APPLICATION NO: 23/00641/FUL/ADDINF

DESCRIPTION: Erection of a metal storage shed and erection of 1.8M high wooden fence. Re-Submission of 22/01021/FUL.

LOCATION: 16 Shropshire Gardens Warfield Bracknell

Site plan for shed

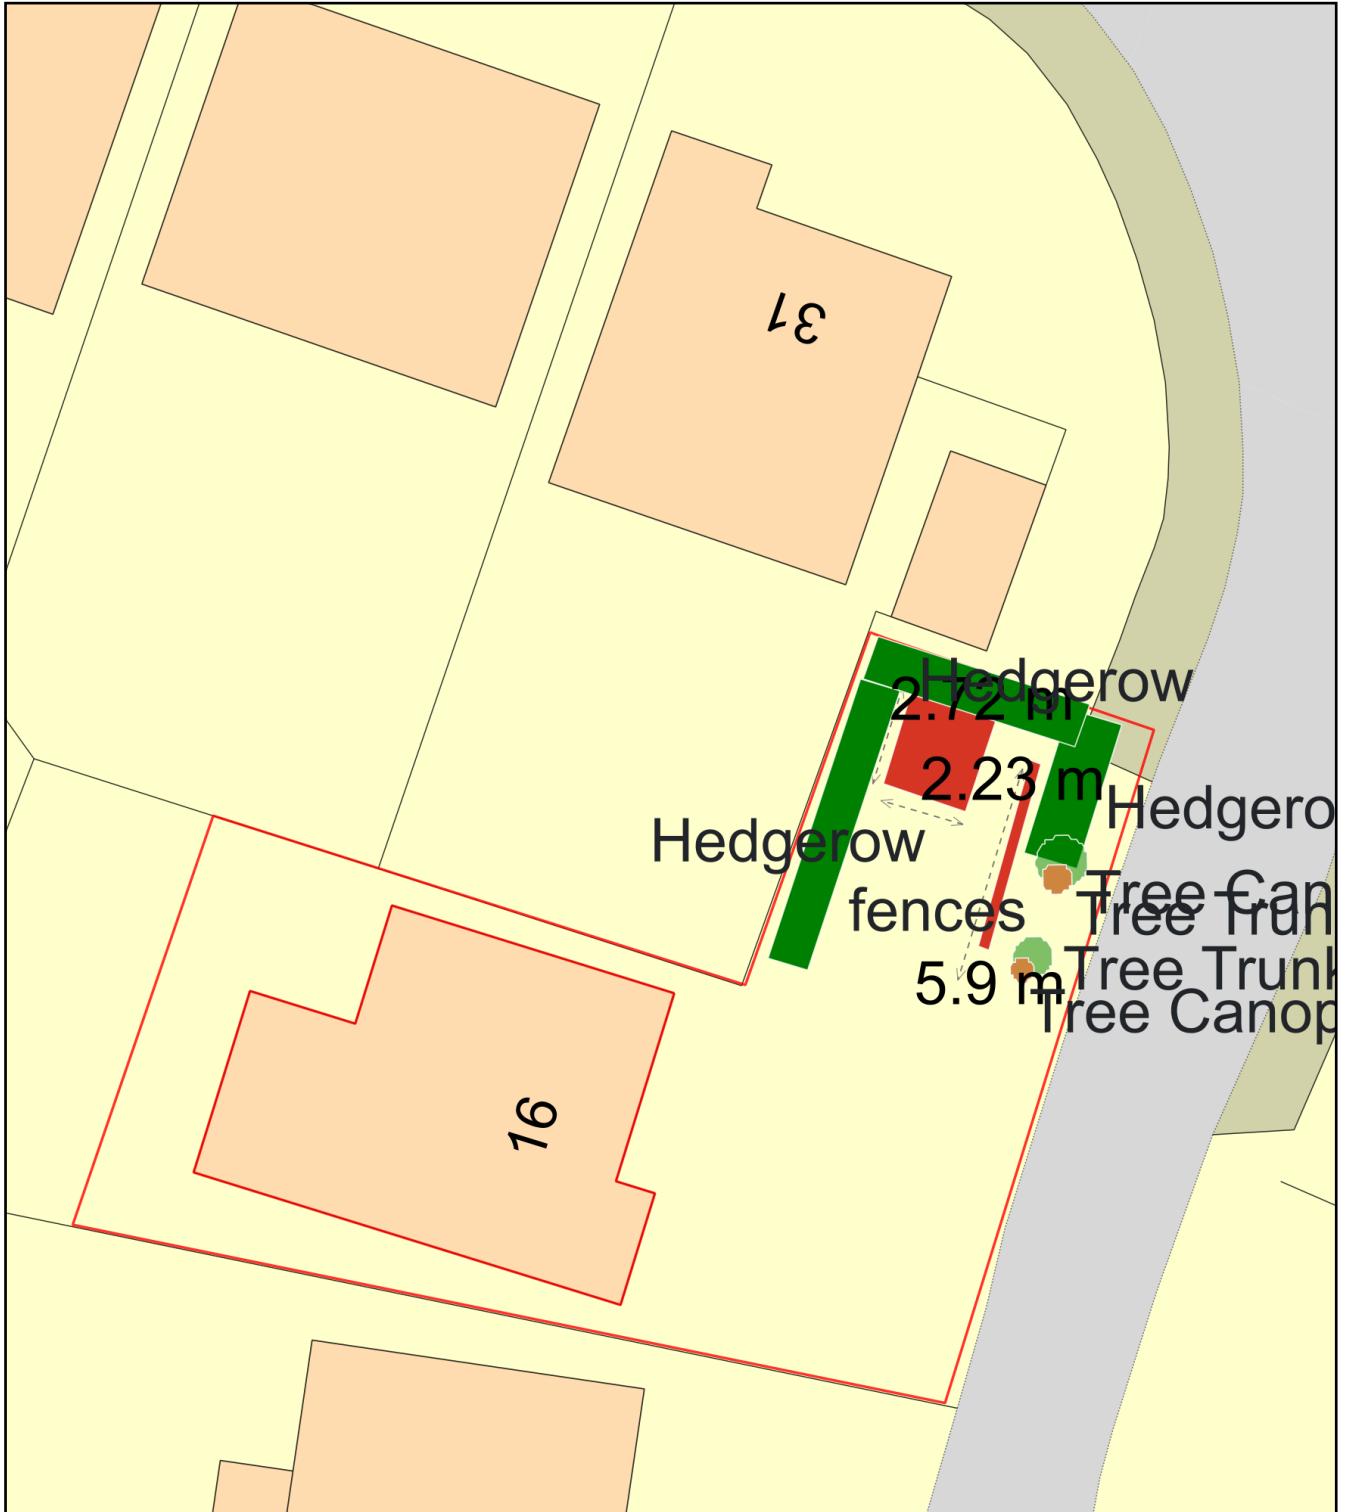
- 1 The block plan submitted with your application shows a hedge but not a proposed fence as stated on your application form. Please show the exact location of the proposed fence(s) on the block plan. We also require elevation plans showing the details of the fence(s) including the posts. Manufacturers details will suffice as long as they are annotated with metric dimensions. Do not submit this additional information through the planning portal. Please email directly to myself.
